From: Matt Brockhurst [REDACTED]
Sent: 30 November 2017 16:14
To: Anita Gardner
Cc: Thomas Rhodes; Phil Acton
Subject: RE: FG/151/17/DOC - Discharge of condition 3 surface water drainage Ferring Country Centre, Ferring
Importance: High

PROPOSED BLOCK/SITE PLAN - 1:250

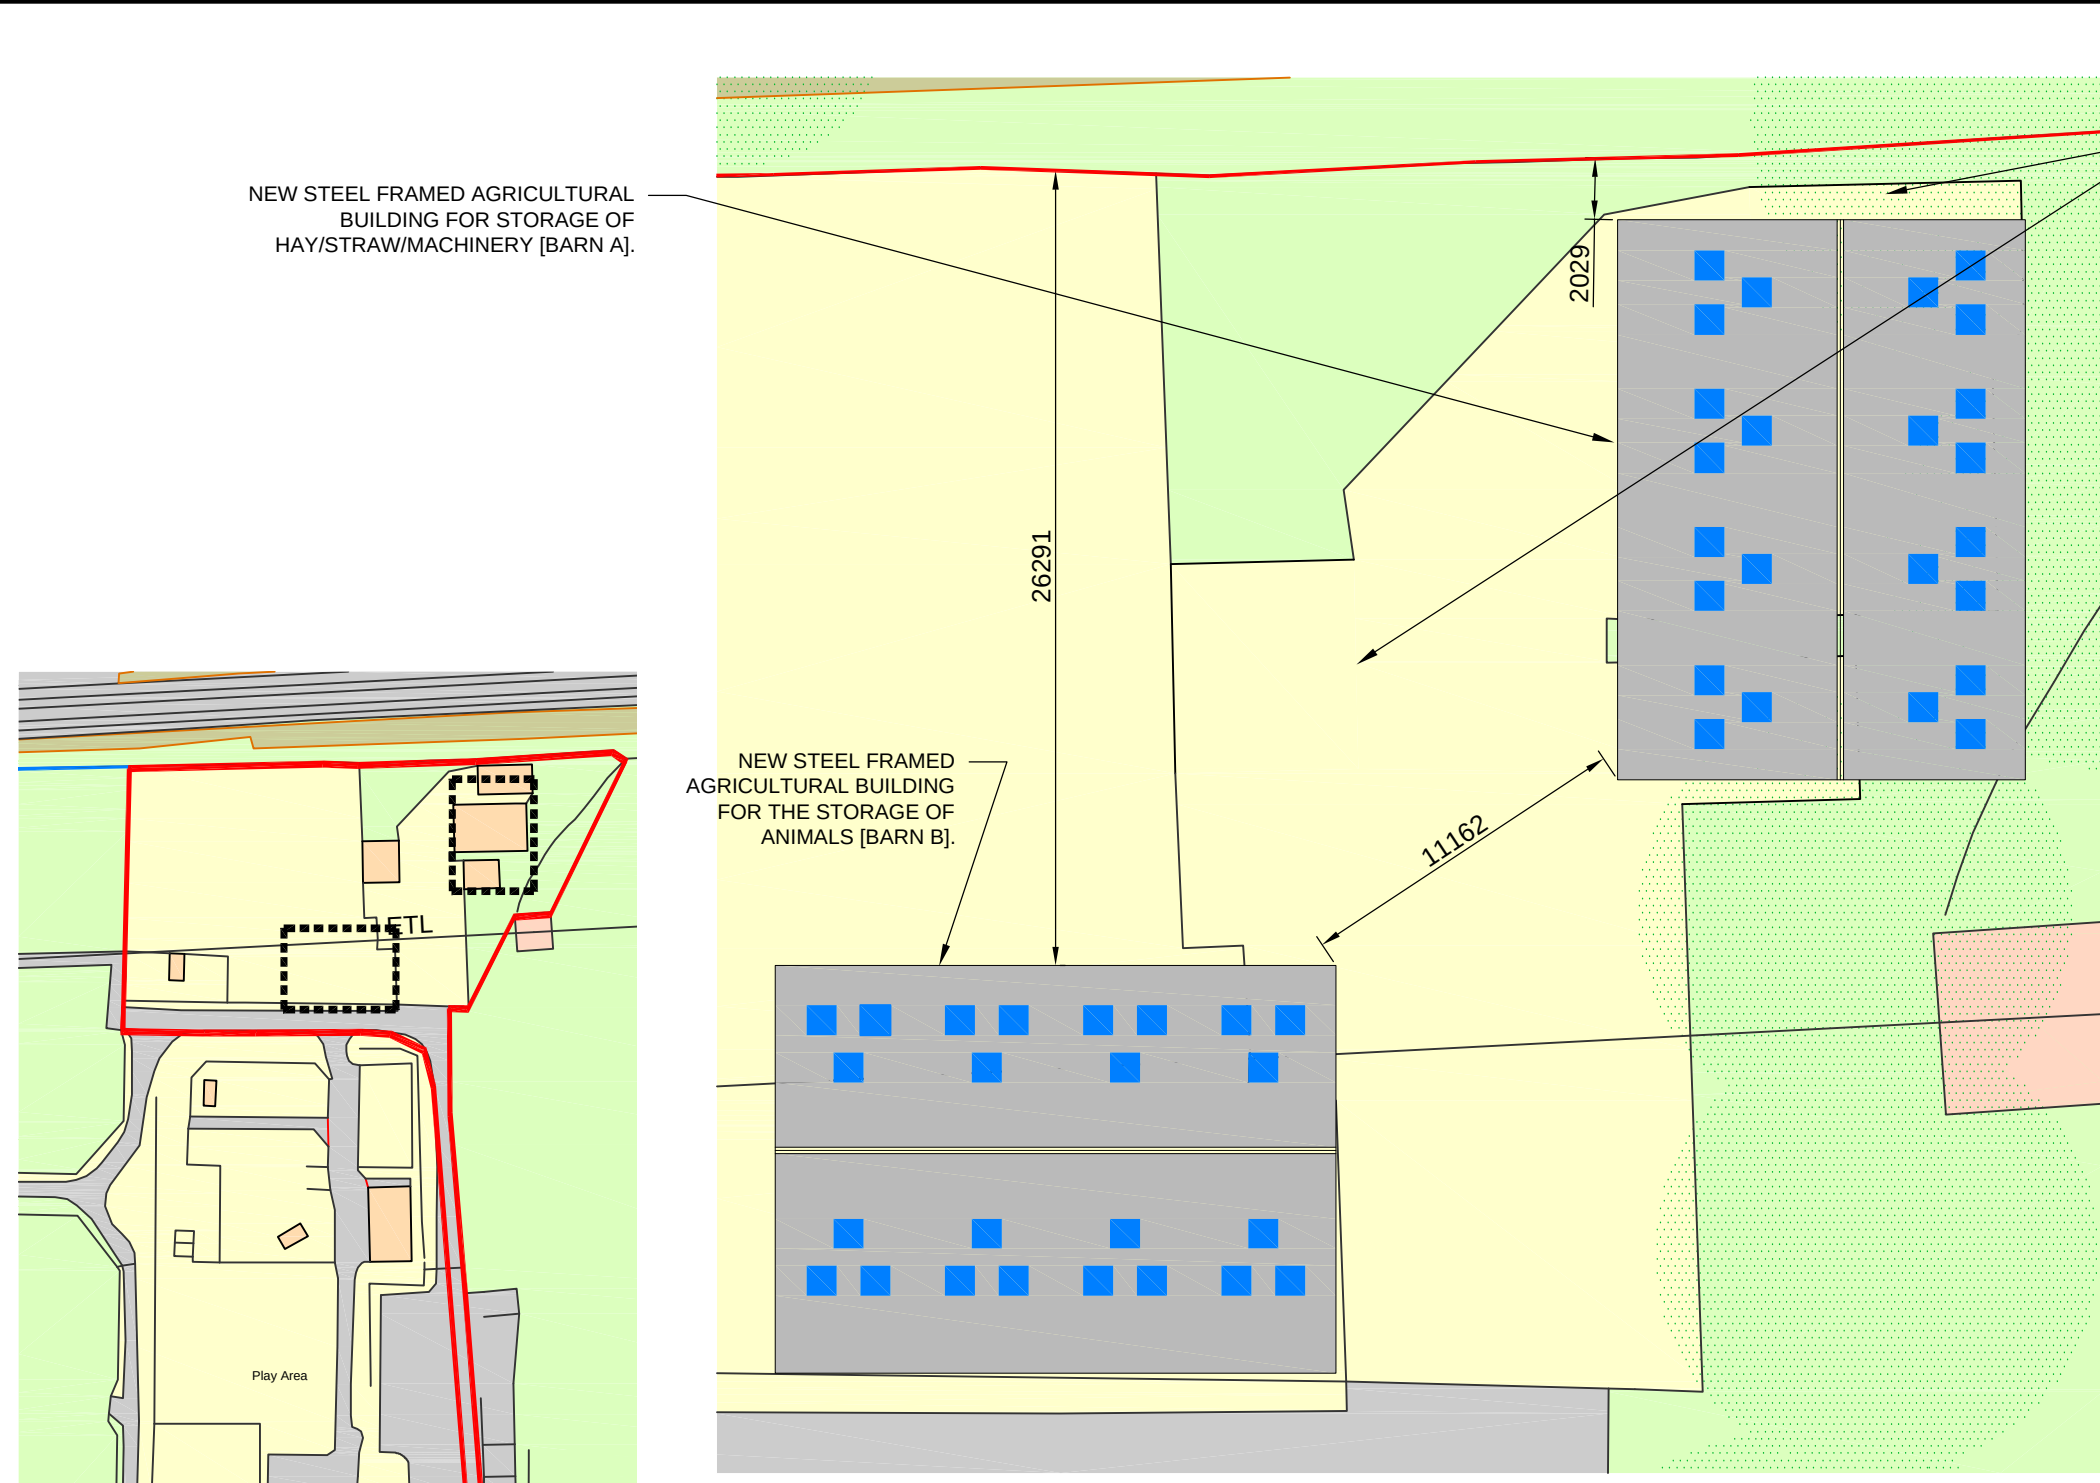
- PL1 revB– general revision inc. existing spot levels.
- PL2 – NB, drainage levels refer to local site datum. Drainage details have been provided including confirmation that the plate soakaway is to be encapsulated within geo-textile membrane.
- Ground investigation report – detailing ground conditions and investigation to determine percolation rates to BS365.
- Schedule of ground water level monitoring – NB, dip levels relate to ground level rather than ordnance datum
